SUBJECT: **BRES2407-0034**
BUILDING RESIDENTIAL

Here are the results of all Inspections located at **121 STEWART FARM LN:**

FOUNDATION PLAN
SCALE : 3/16" = 1'-0"

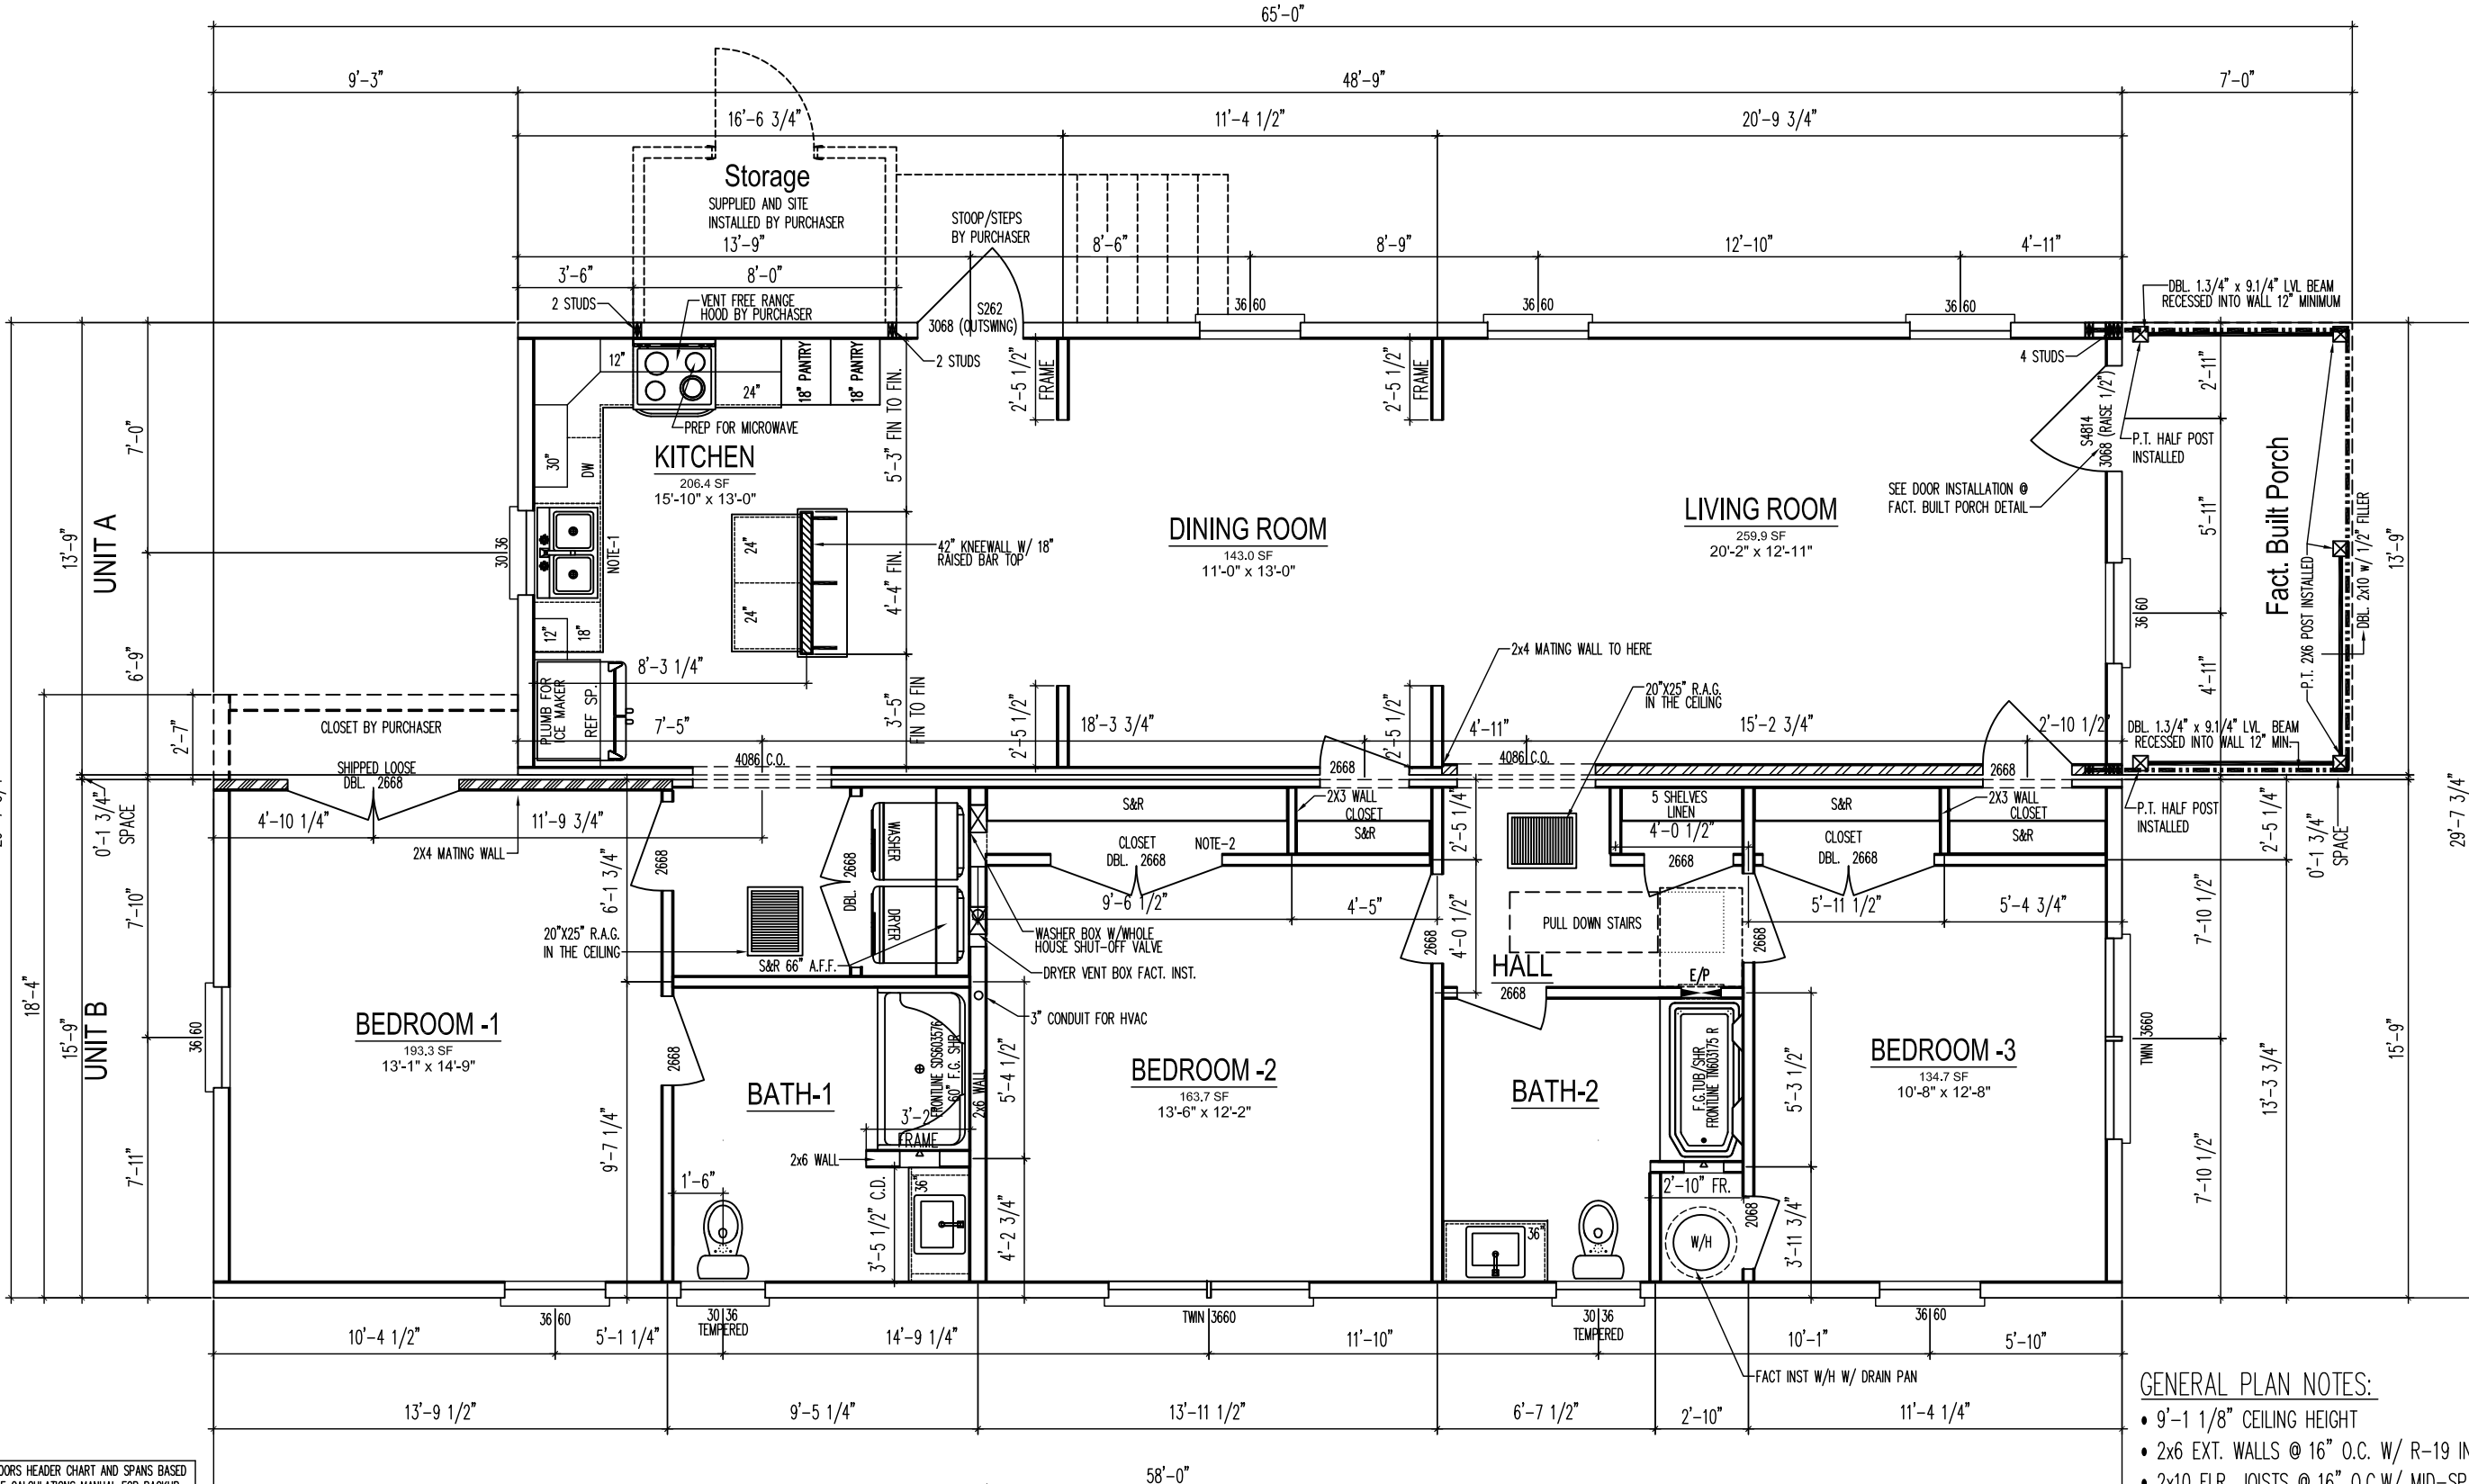
Inspection Type: FOUNDATION
Scheduled Date/Time: 6/17/2025
Completed Date/Time: 6/17/2025
Inspector: Deen Taylor
Result: DISAPPROVED
Remarks:

Notes: Top of footing must be exposed for foundation inspection to verify bed joint and projection.
Top of footing must be exposed for foundation inspection to verify bed joint and projection.
